Charlotte Storm Water
600 East Fourth Street
Charlotte, N C 28202-2844

Rezoning Petition Review

Date of Review: March 23, 2020 (*Revised April 16, 2020*)

Rezoning Petition #: 20-30

SCHEMATIC
SITE PLAN

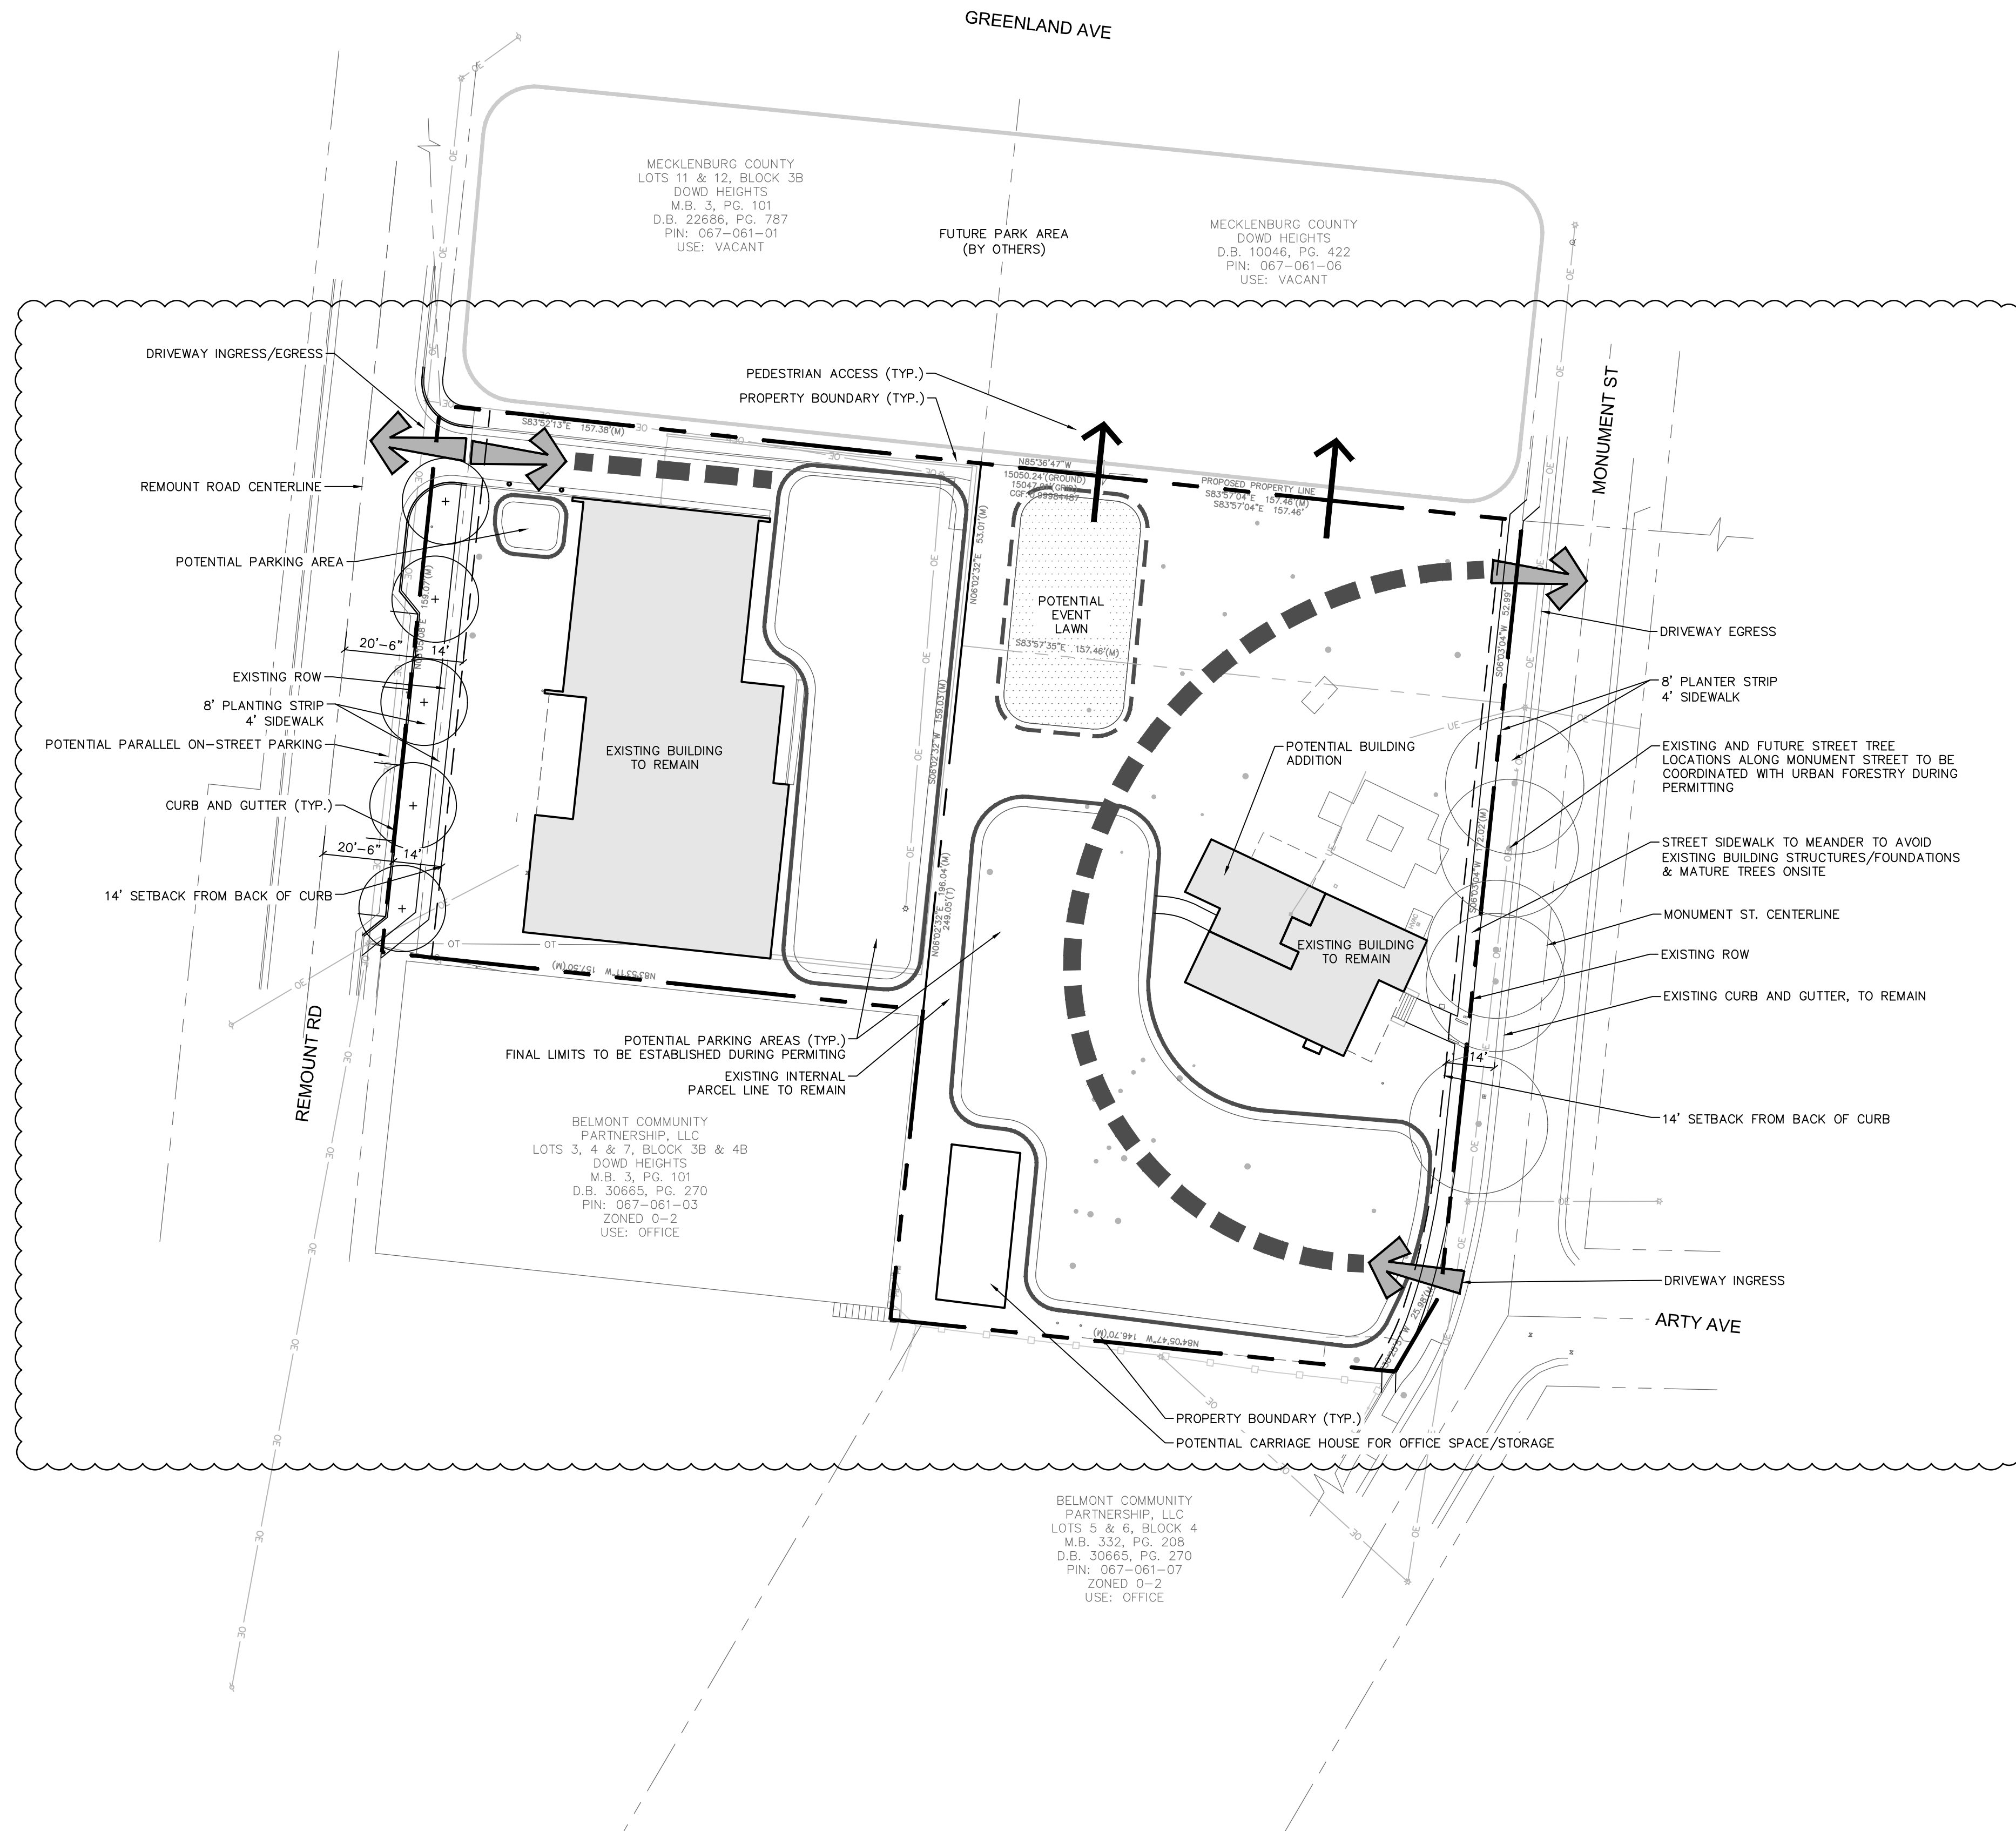
This property drains to Irwin Creek, which is an impaired/degraded stream, and may contribute to downstream flooding. This project has the opportunity to mitigate future impacts to this stream, therefore, Storm Water recommends placing the following notes on the plan:

(I) Storm Water Quality Treatment

For defined watersheds greater than 24% built-upon area (BUA), construct water quality stormwater control measures (SCMs) designed for the runoff generated from the first 1-inch of rainfall for all new and redeveloped BUA associated with the project. SCMs must be designed and constructed in accordance with the Charlotte-Mecklenburg BMP Design Manual.

(II) Volume and Peak Control

For defined watersheds greater than 24% built-upon area, control the entire volume for the 1-year, 24-hour storm for all new and redeveloped BUA associated with the project. Runoff volume drawdown time shall be in accordance with the Charlotte-Mecklenburg BMP Design Manual.

For commercial projects with greater than 24% BUA, control the peak to not exceed the predevelopment runoff rates for the 10-yr, 6-hr storm and perform a downstream flood analysis to determine whether additional peak control is needed and if so, for what level of storm frequency, or if a downstream analysis is not performed, control the peak for the 10-yr and 25-yr, 6-hour storms.

For residential projects with greater than 24% BUA, control the peak to not exceed the predevelopment runoff rates for the 10-year and 25-year, 6-hour storms or perform a downstream analysis to determine whether peak control is needed, and if so, for what level of storm frequency.
